Application no: H23/0270/09

Description: Replacement bungalow

Location: 107 Broadgate
Whaplode Drove

From: Gedney, David [mailto:DGedney@sholland.gov.uk]
Sent: 08 June 2009 16:59
To: Remway Design - Jason Wilson
Subject: H23/0270/09 - Proposed replacement bungalow, 107 Broadgate, Whaplode Drove - Mr D Fines

Drawing No:
A3-1708-01"B"

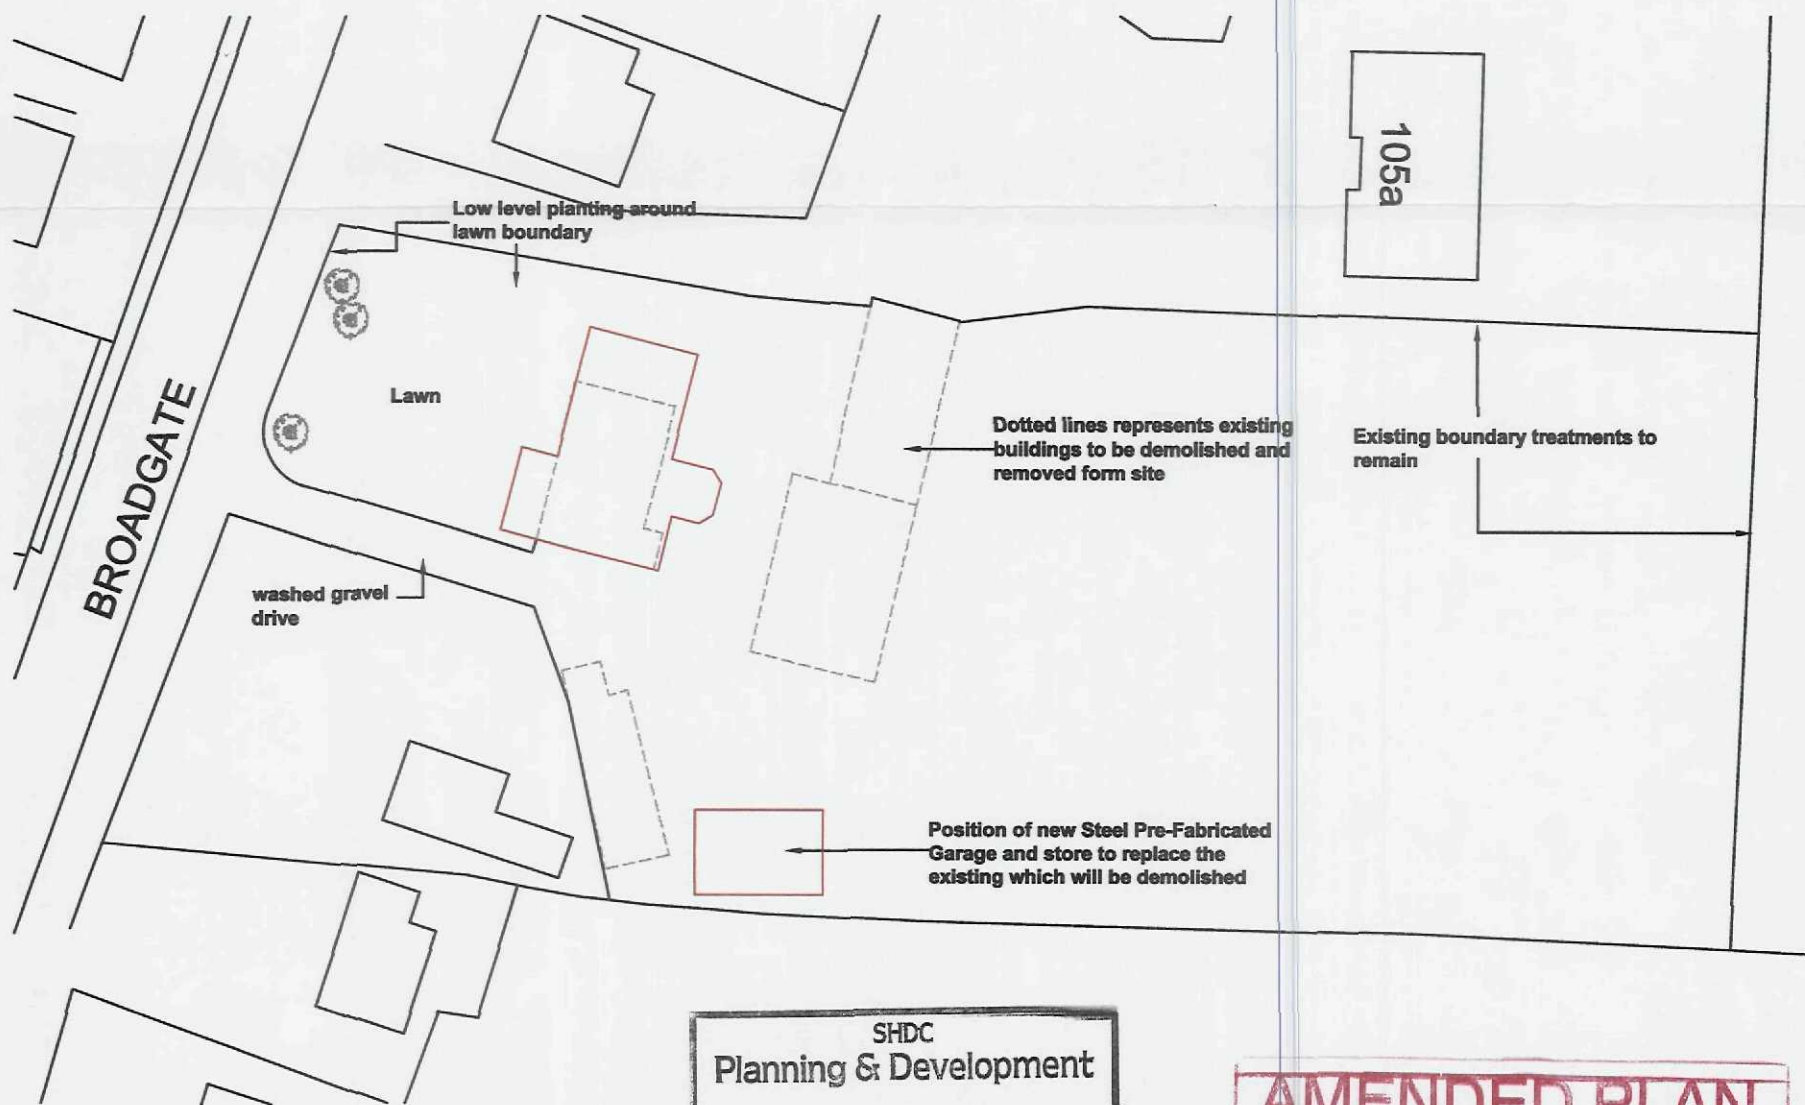
In order for the proposal to be acceptable the site (as outlined in red) needs to be reduced to the same size as the previous approval (ref H23/0270/09). A copy of the previous site is attached for information.
The remainder of the land should be outlined in blue and will be outside the residential curtilage.

Amendment: Revised site boundary (dwg. no. 1708-01B)

Amended site location plan.

Drawing No:
A3-1708-01"A"

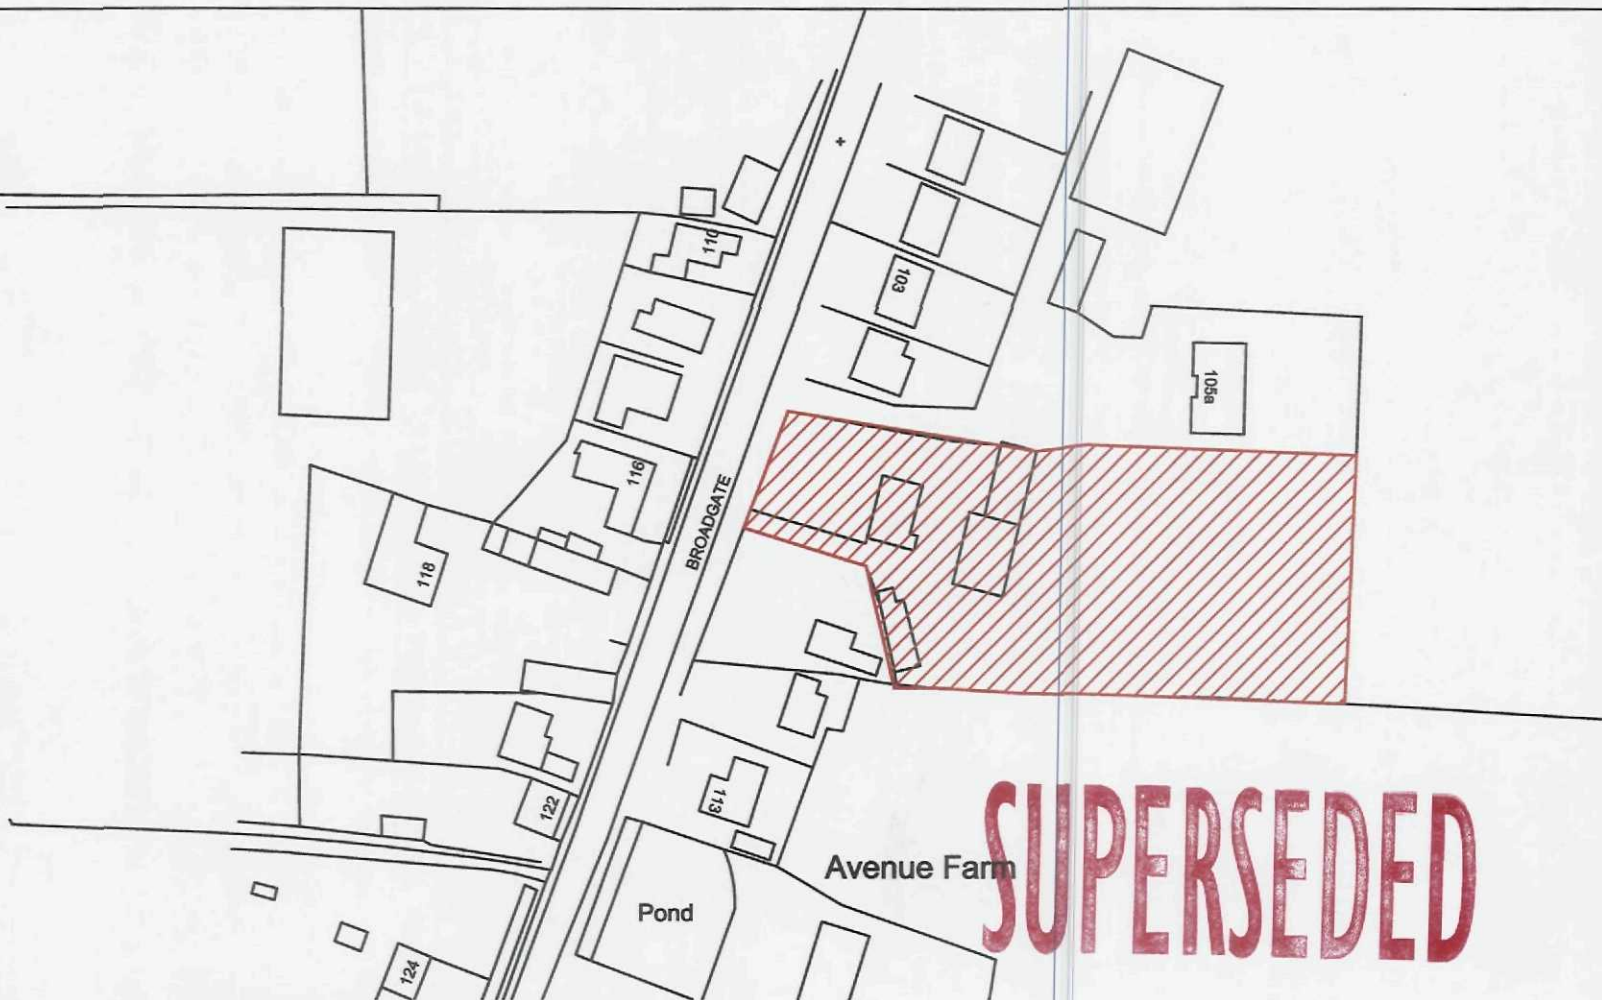
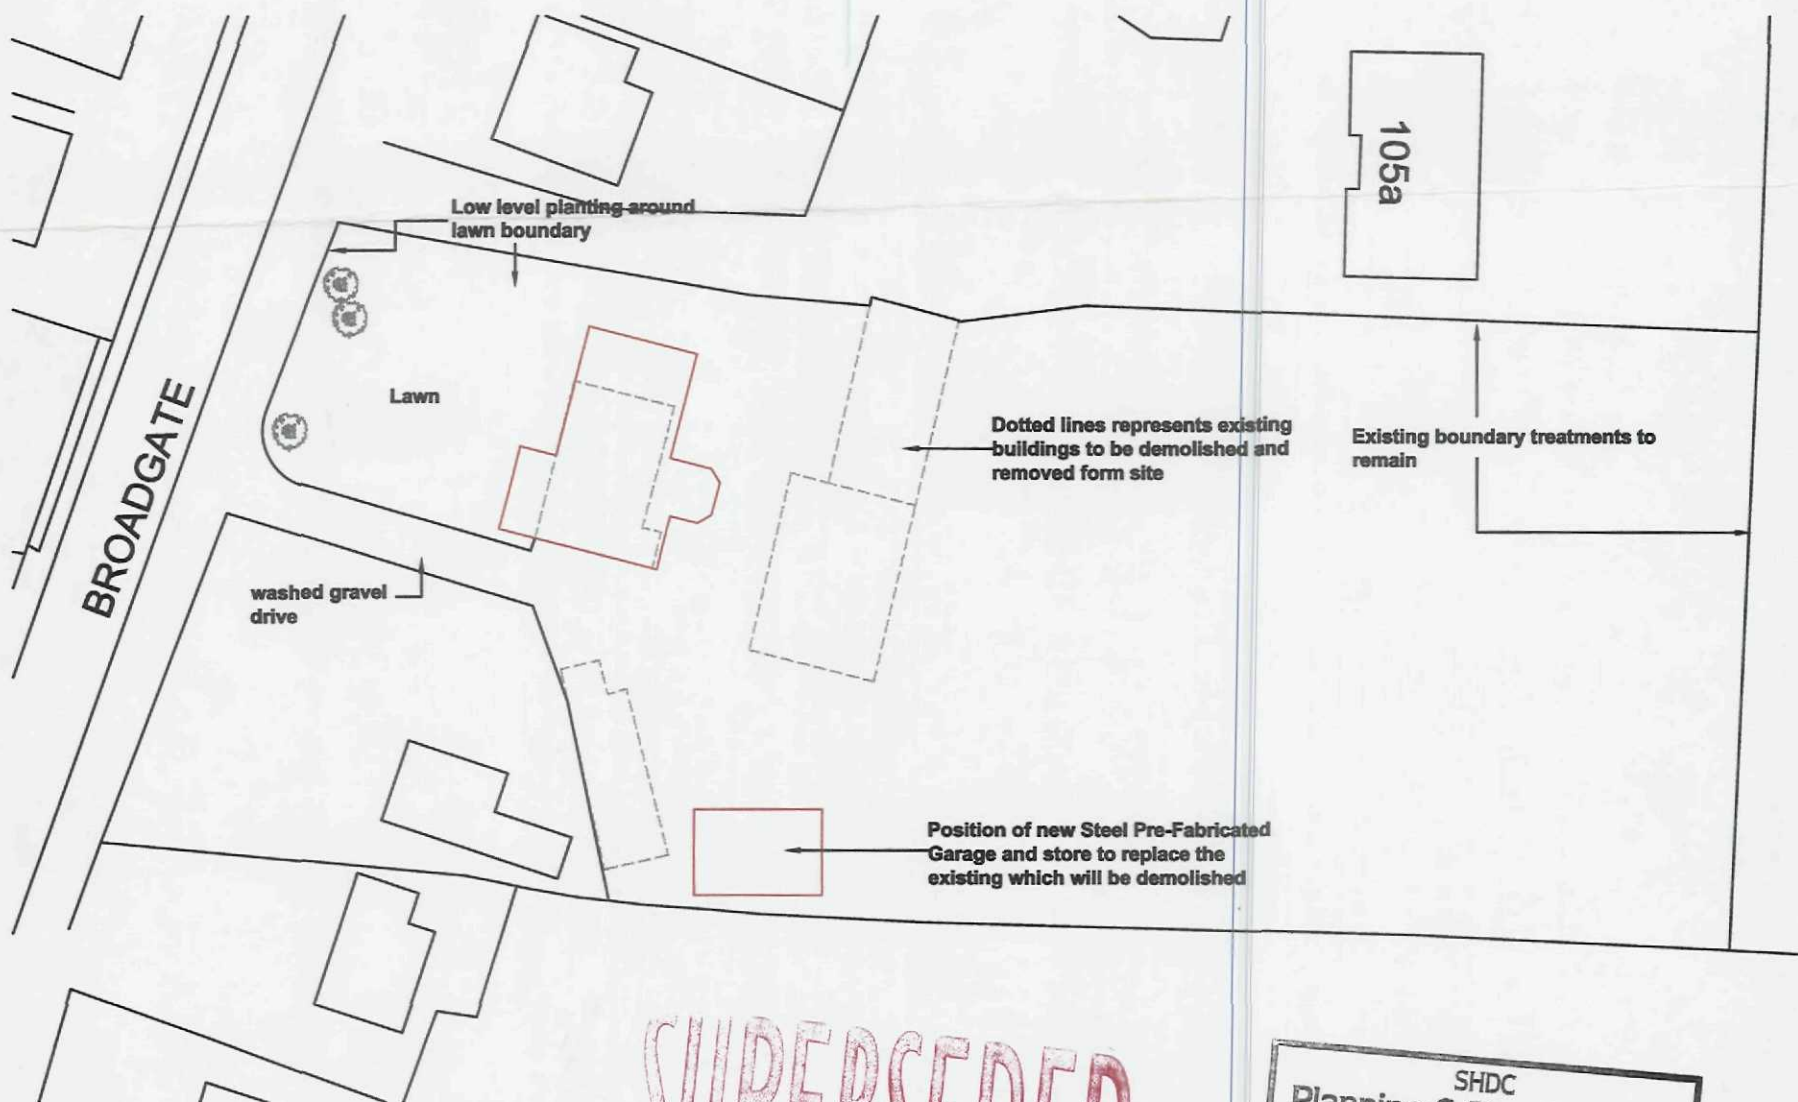
In addition, the scheme will need to include significant landscaping/tree planting along the frontage to replace those removed.
This can be conditioned if so required.

It is noted that a new garage is required. Please provide elevations and a layout plan or exclude it from the block plan.

Please condition garage and planting
